Lr.No. 41/15399/90

Dated: 20-8-'90

Sub: MMDA - Planning Permission - Construction
of Residential building in Plot No.9B at S.No.
60pt. of Ullagaram Village - Approval of -
Regarding.

Revised Plan
P.C. 4/9/90

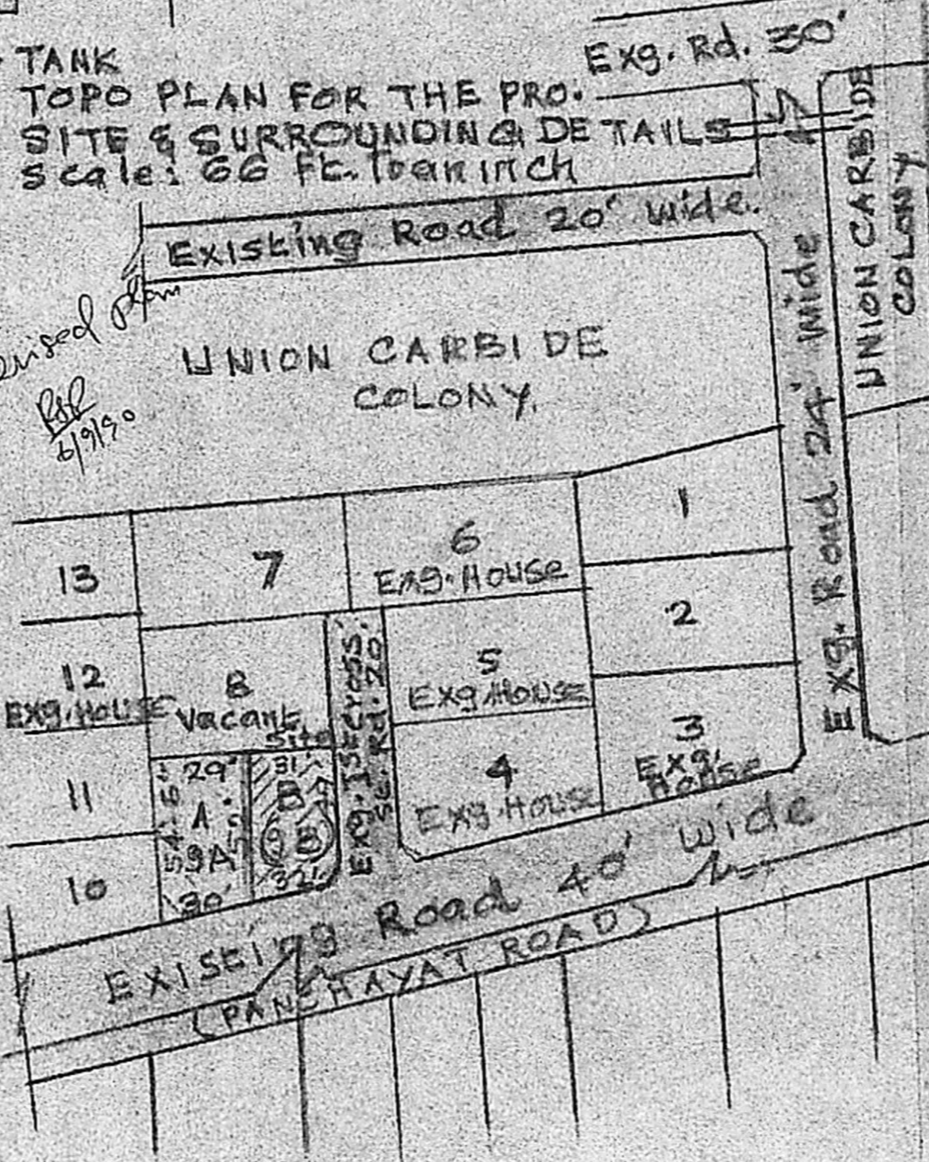
towards regularisation charge by two separate Demand Drafts of a
Nationalised Bank in Madras City drawn in favour of the Member-
Secretary, MMDA, Madras-8 or in cash/and pay at MMDA office cash
counter between 10.00A.M. and 4.00 P.M. within 10 days and after
remit the said amount, you are requested to remit the duplicate
receipt to Area Plans Unit. You are also requested to submit the
Affidavit for ULC in Rs.5/- stamp paper duly attested by Notary
public. Planning Permission application will be returned unapproved
if the amount are not paid within the stipulated time. Also you
are requested to furnish a Revised Plans of Splay 3.0mts. x 3mts.
